DECISION DELEGATED TO HEAD OF PLANNING

Application No: H16-0167-26 **Applicant:** E Stefanak
Proposal: Single storey rear extension joining to the existing garage
Location: 74 Tyne Close Spalding Lincolnshire
Terminal Date: 4th May 2026

CASE OFFICER ASSESSMENT

Proposed Front Elevation
1:100

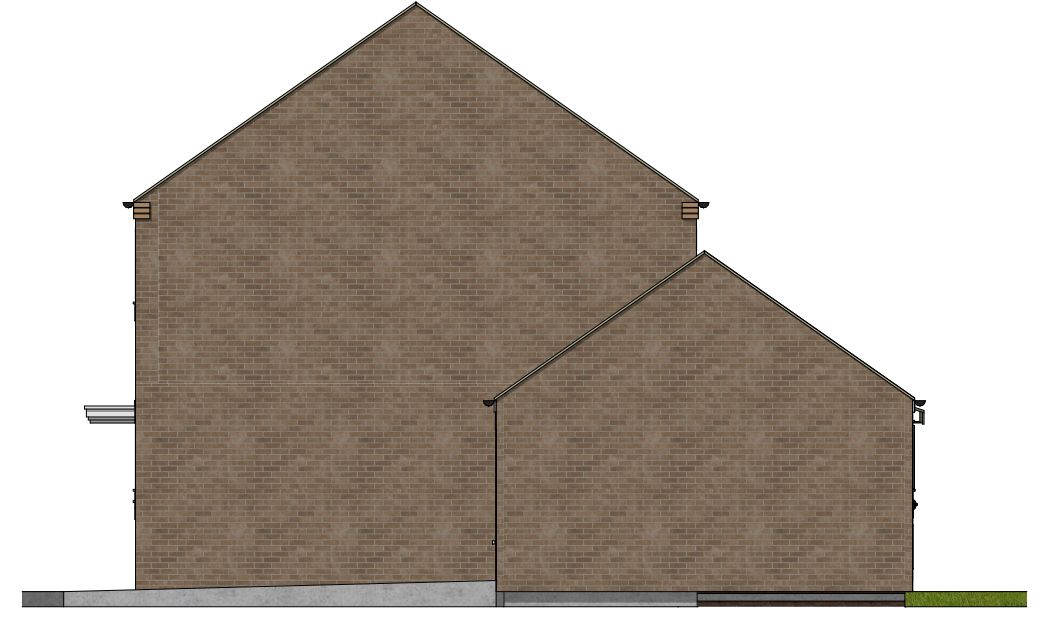
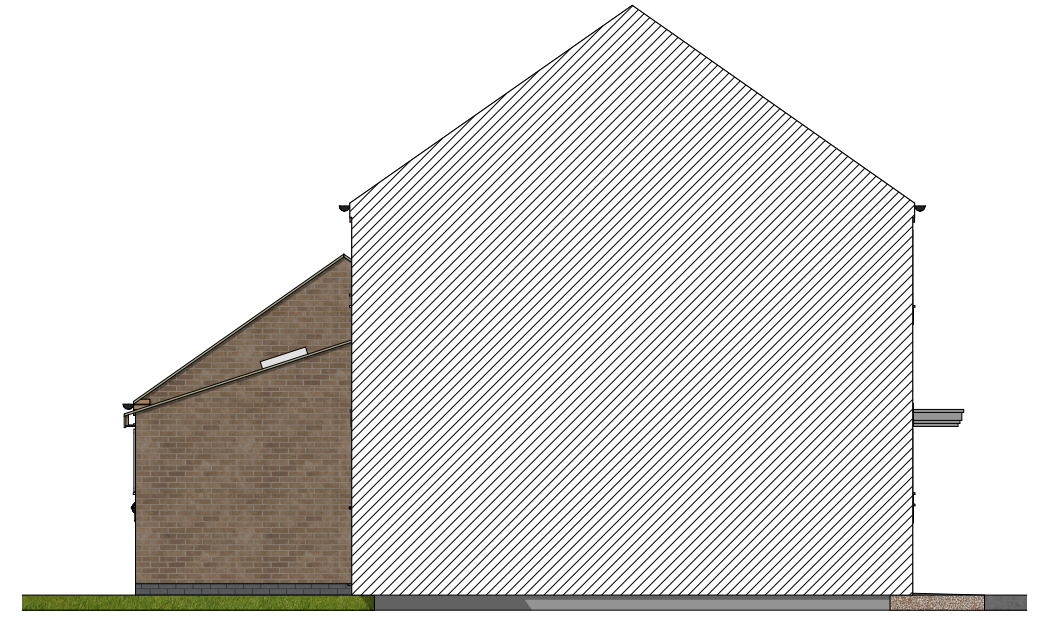
Only a small section of the extension would be visible, namely the brickwork above the door of the link between the house and the garage. This section would appear awkward and lack full integration with the host. The effect of this would be exacerbated by the solidity of the brickwork visible. That being said, this area is not prominent and only occupies approximately 0.9m. Views of the link could only occur when directly facing the linkway, meaning that there would not be an overly significant visual impact. On the basis of the lack of visibility of the extension, the tangible impact of the development is considered to be low. As a result, it cannot be said that the proposal would be harmful to character or appearance of the area.

Proposed Ground Floor Plan 1:50

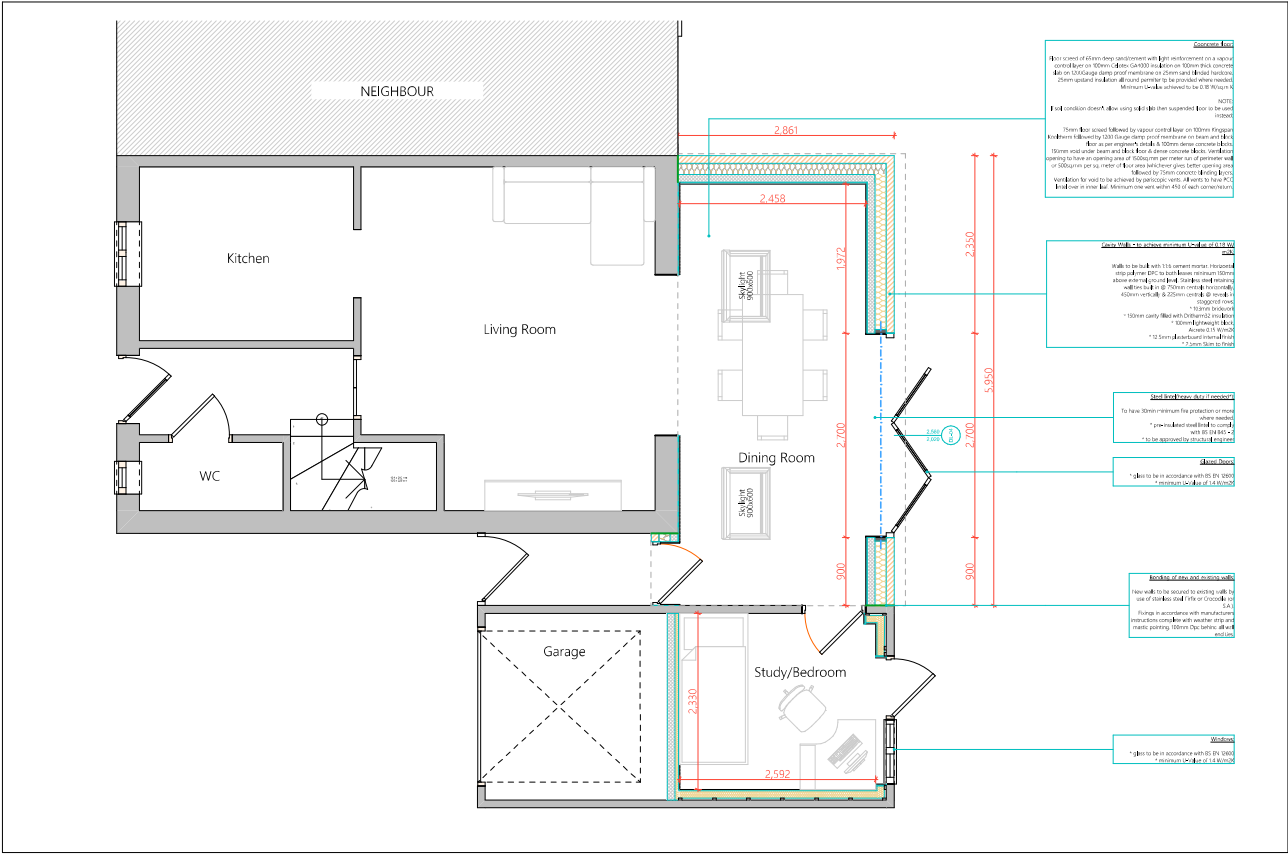
The extension would measure 2.861m (depth) by 5.950m (width). To the eaves, it would measure 2.4m, rising to 3.375m at the junction with the wall and 3.475m at the link section. The rear of the garage would be converted to a study.

The proposal would result in a decrease in parking space available. However, this would not be significantly detrimental to highway safety due to the scale of the impact. Moreover, it should be
